Goodchild Marine Services Limited,
Burgh Castle Yacht Station, Butt Lane, Burgh Castle, Great Yarmouth, Norfolk, NR31 9PZ.
Tel: **01493 782301** Fax: **01493 782306**
E-mail: info@goodchildmarine.co.uk Web: www.goodchildmarine.co.uk

For the attention of Dominic Young
The Planning Inspectorate
National Infrastructure Planning
Temple Quay House
2 The Square
Bristol
BS1 6PN

GYTRC@planninginspectorate.gov.uk
Your reference TR010043

Please find as follows our submission for the Deadline 1 Following on from the meeting of the 24th September at Great Yarmouth

DRAWING TITLE
 DCO DOCUMENT 2.14
 NEW BRIDGE AREA PLAN
 (REGULATION (5)(2)(o))

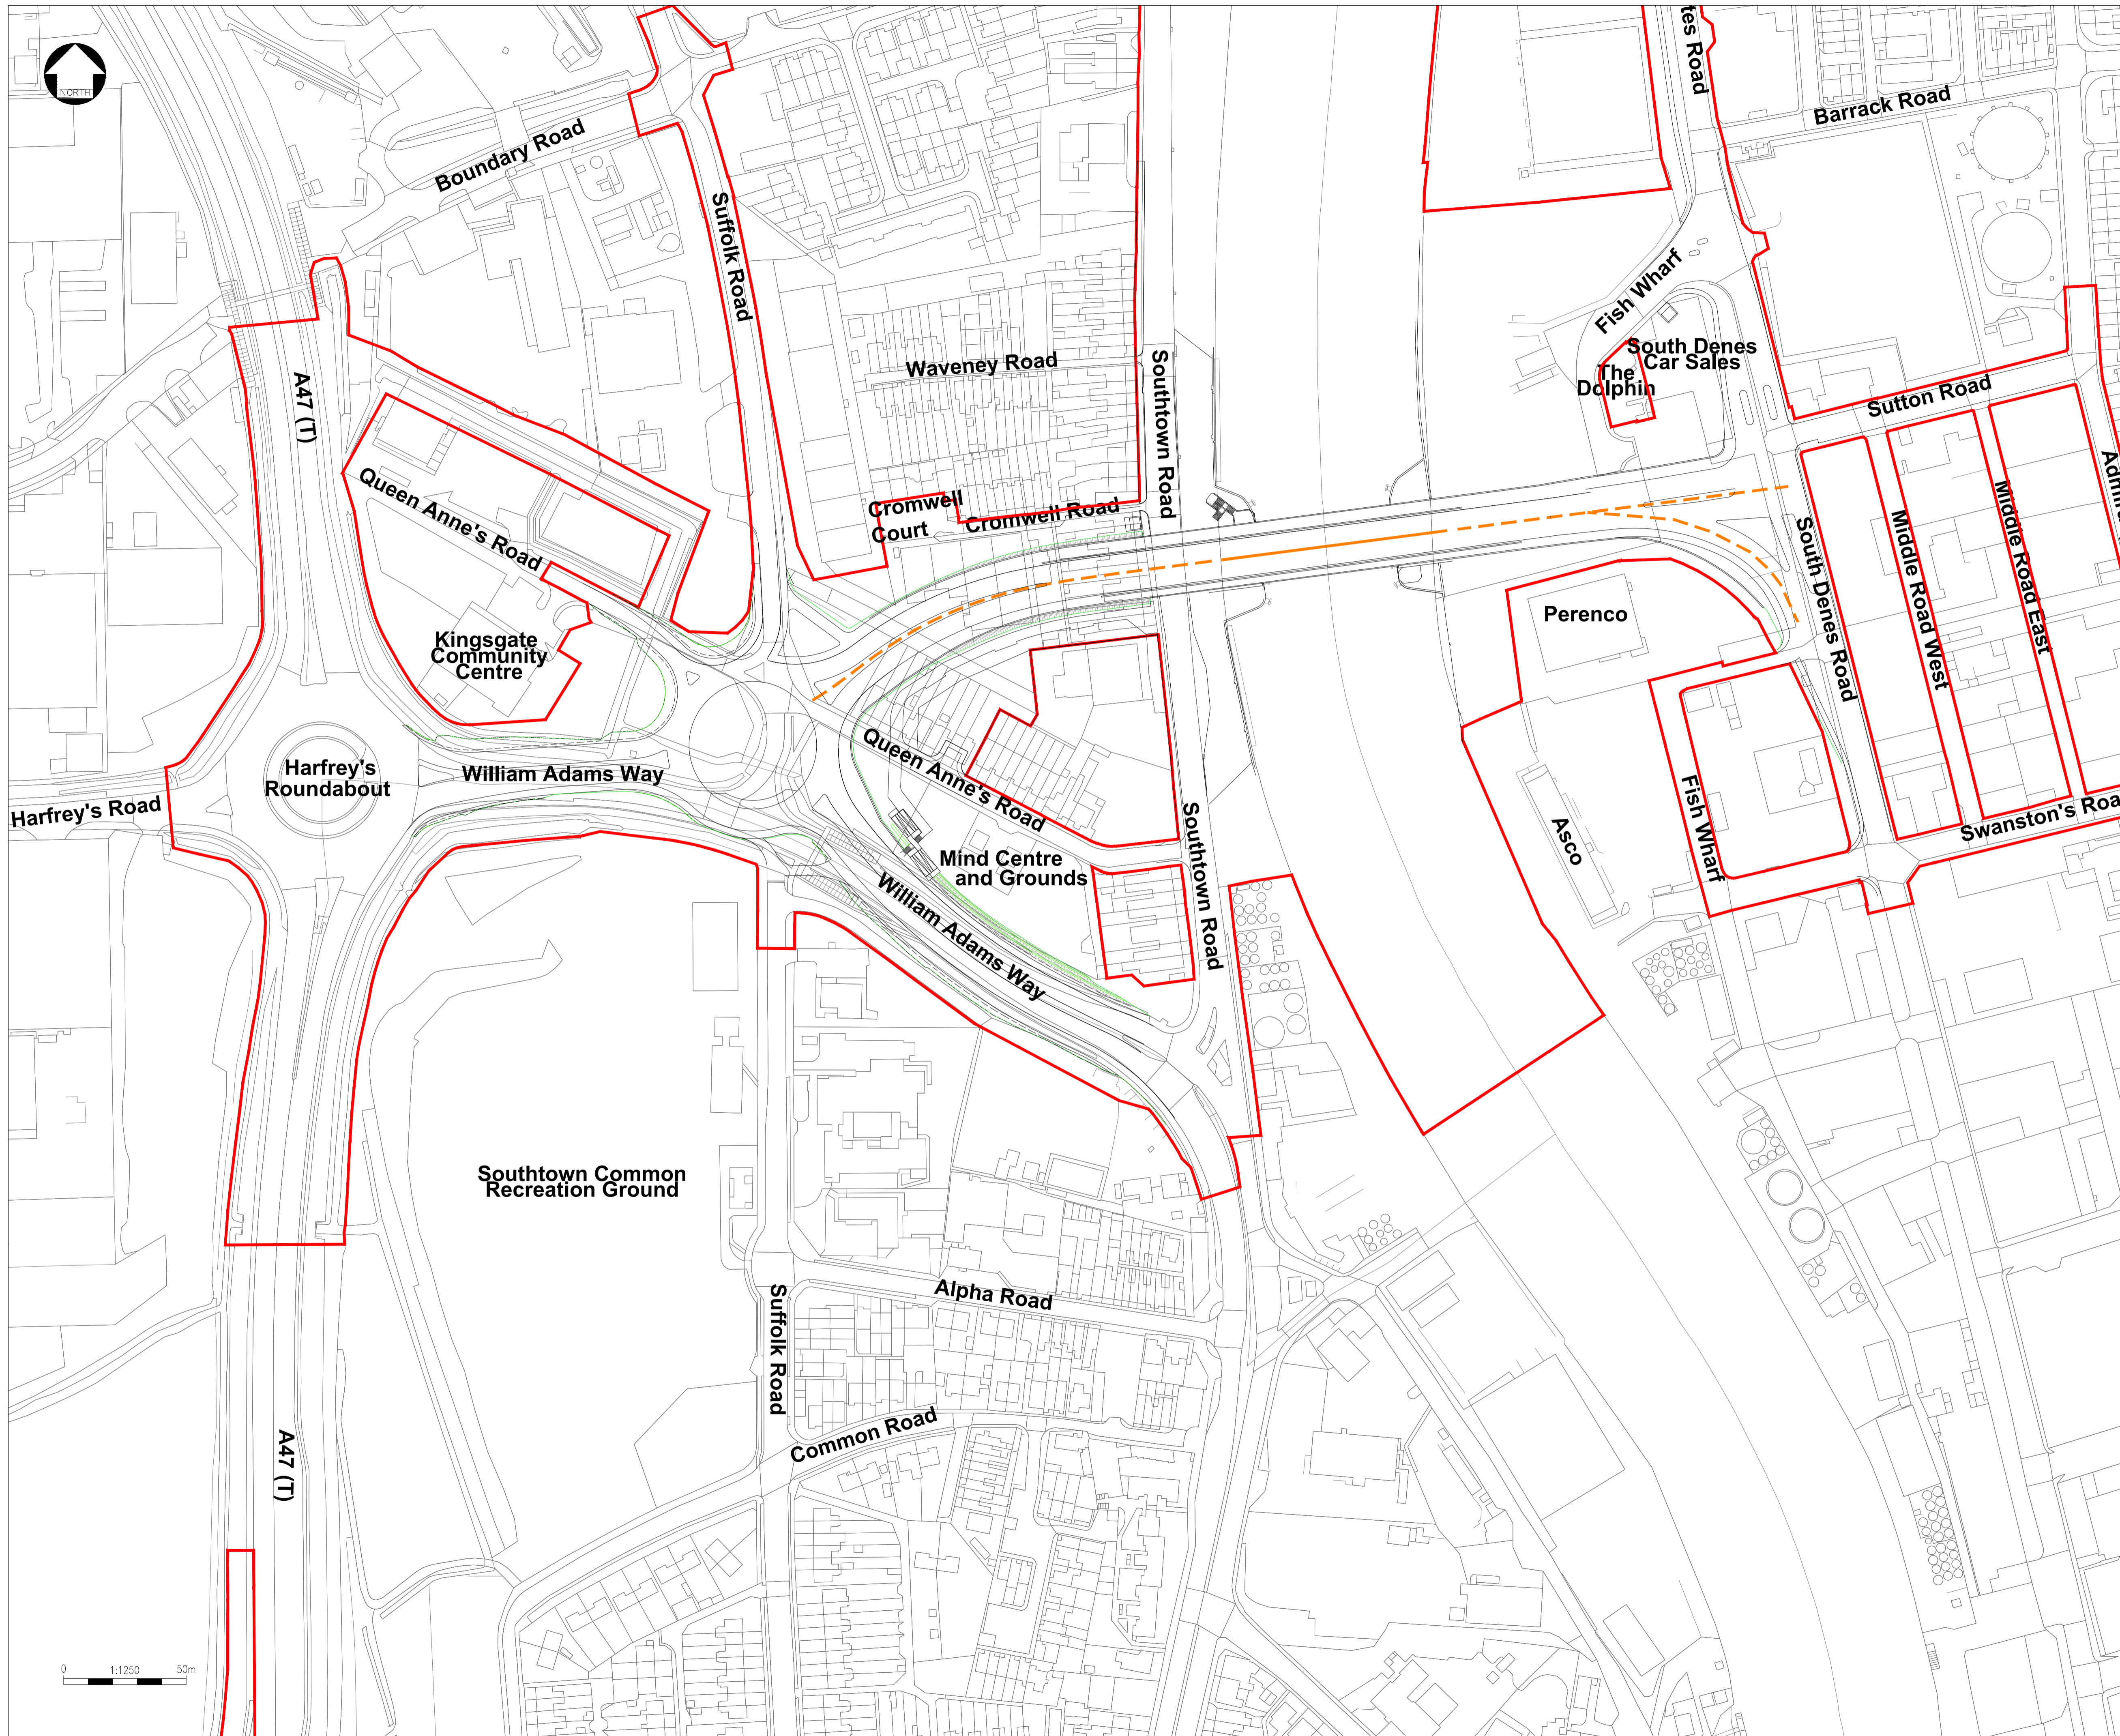
It is welcomed to see on the drawings that waiting pontoons are being introduced adjacent to the new bridge foundation. However, having these so close to the bridge and on the outside of a natural bend in the river is inviting a disaster. Any large vessels that are transiting the open bridge are likely to drift outboard on a bend (simply nature of steering vessel when underway). Having these on the outside of a bend I would suggest is not the best solution and is inviting damage or worst sinking of any small craft moored there. If they must remain close to the bridge it would make much more sense to have these on the opposite side (inside of the rivers bend) which is much better protected should a vessel get things wrong. The stern of a vessel negotiating such a bend is extremely unlikely to drift into the bend.
